About the application

Application number: 2023/91459	
What is the application for?:	Erection of extension and associated alterations
Address of the site or building:	268, Halifax Road, Hightown, Liversedge, WF15 6NP
Postcode:	WF15 6NP

Proposed block plan (1:500)

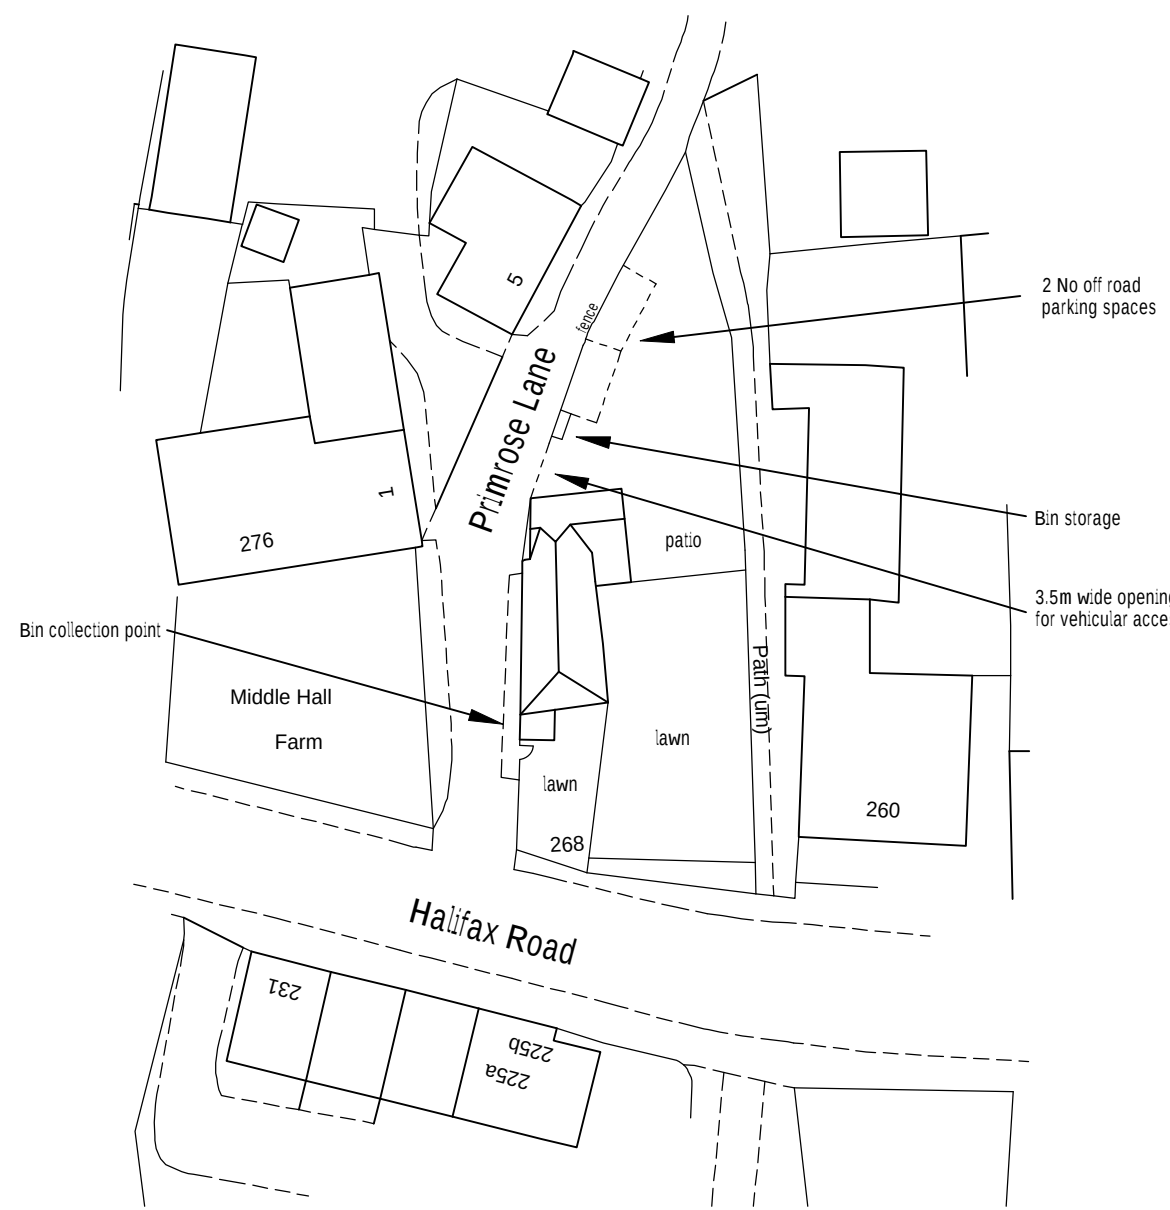
Type of comment: An objection	
Do you wish your comments to be published on the website anonymously?	Yes
<p>1. Change to boundary of ownership - on previous applications the second toilet block facing onto land owned by Kirklees council (previously there was a Kirklees No Ball Games sign) was not highlighted as their ownership. It appears they have extended the boundary line on the proposal to allow for the extension, however unless they have suddenly purchased this toilet block, it seems convenient. This should be checked.</p> <p>2. Visibility onto primrose lane - with the extension, it appears to reduce the visibility onto primrose lane towards Halifax road. This is a public bridleway and would present a danger to pedestrians and horse riders.</p> <p>3. Position of the parking- it is not clear how the parking spaces would be used and what provisions have been taken into account for turning etc. The reduced visibility and access is not sufficient according to the Local Plan LP21 part "e".</p> <p>Plus Privacy loss due too side elevations bedroom window looking straight into another's habitable windows contrary to planning policy not the required safe distance</p>
